Re: Plan Deviation Letter
187 Dewar Street
Fuquay Varina, NC

The scope of this project was limited to inspection and evaluation of multiple plan deviations and framing concerns denoted in a recent city framing inspection at the addition under construction based on the latest revision of the structural plan drawings issued by Giles Flythe Engineers dated December 17, 2024. The evaluated conditions included the following:

Residential Single-Family Project: <input checked="" type="checkbox"/> Y <input type="checkbox"/> N	Commercial Project: Y <input checked="" type="checkbox"/> N <input type="checkbox"/>
Code Enforcement Project No:	Permit No: BRES2404-0096
Project Name: <i>Sturgess Residence Addition</i>	Owner: <i>Peter Sturgess</i>
Project Address: <i>187 Dewar Street, Fuquay Varina</i>	Suite No:
Date Inspected: <i>1/10/2025</i>	Contractor Name: <i>Butler Homes, LLC</i>
Component Inspected: <i>Various plan deviations (anchor bolts, roof framing, porch posts)</i>

ROOF FRAMING PLAN
SCALE: 1/4" = 1'-0"

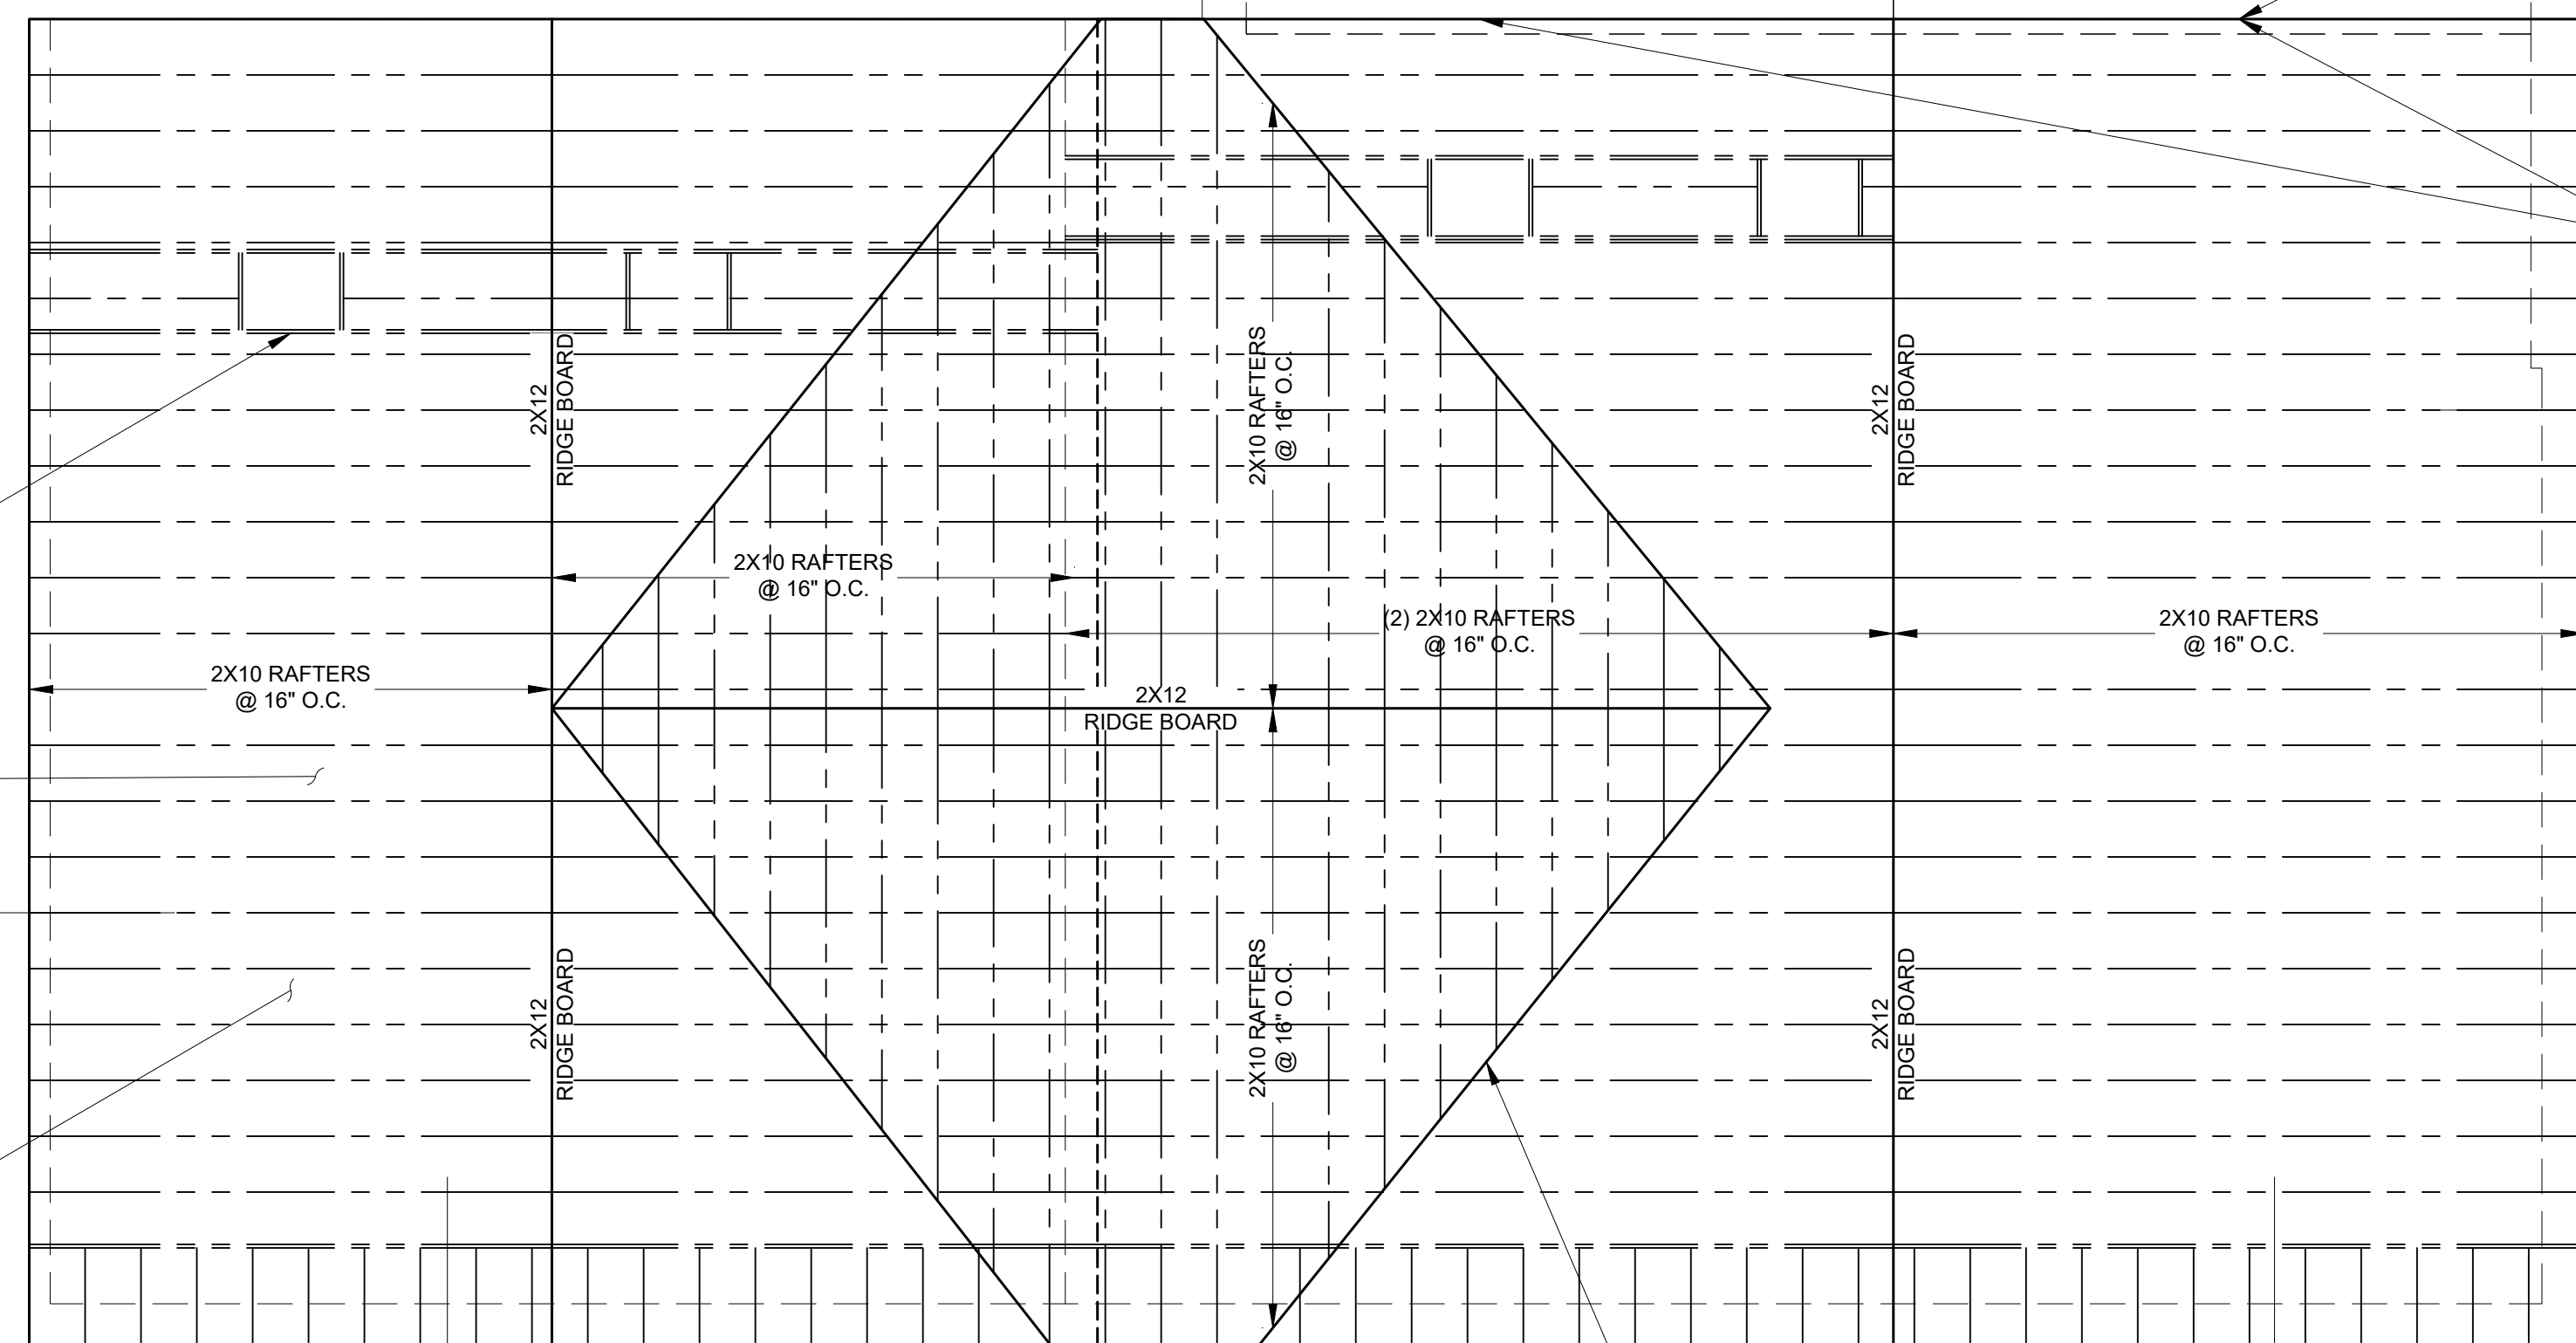
2. A portion of the existing porch roof framing was integrated into the new porch addition starting at the rear exterior wall of the existing house structure and extending rearward approximately 6'-6". The integrated framing spanned the length of the new porch addition (\approx 11'-3" left to right). New 2x6 ceiling joists were installed spanning left to right attached at the right heel joint of the integrated roof framing using nail-type fasteners. The rafters were noted to bear on the continuous 2-2x10 header extending from the rear-right corner of the house structure specified on Sheet S4.0, "Ceiling/Wall Framing Plan" in the structural plan drawings. The integrated roof framing was attached to the header using Simpson H2.5A hurricane ties. A new 2x4 knee wall comprised of 2x4 studs at 16" O.C. with a 2x4 sill plate and 2x4 top plate was installed above the left perimeter of the porch addition below the existing, integrated porch roof framing.

5. The ceiling framing within the foyer/porch area of the front addition was framed in a differing manner from that specified in the structural plan drawings. The elevated rafter ties were installed continuous spanning from the right exterior wall (entry wall) leftward towards the right perimeter wall of the garage (span = 17'-8"). The 2-2x10 flush beam denoted on Sheet S4.0, "Ceiling/Wall Framing Plan" in the structural plan drawings was noted installed. Furthermore, a single skylight was installed in lieu of the two skylights shown on the plan drawings.

2. The integrated roof framing and installed framing renovations at the front area of the rear porch addition (Observation #2) are adequate to support the design loading conditions in their current configuration. No further repairs/modifications are required.

5. We recommend sistering the all single-ply rafters on the left side of the ridge board above the foyer/porch area of the front addition (Observation #5) for their full lengths (ridge to right perimeter wall of garage) using 2x10 members to create new 2-ply rafter members. The new sisters shall be installed using (3) 10d common nails at 16" O.C. The new sister plies shall be attached at the ridge board using Simpson L90 clip angles (or approved equivalent). Verify the installed rafter ties are attached at the heel joints per the specifications denoted in detail 2/S4.0 in the structural plan drawings.
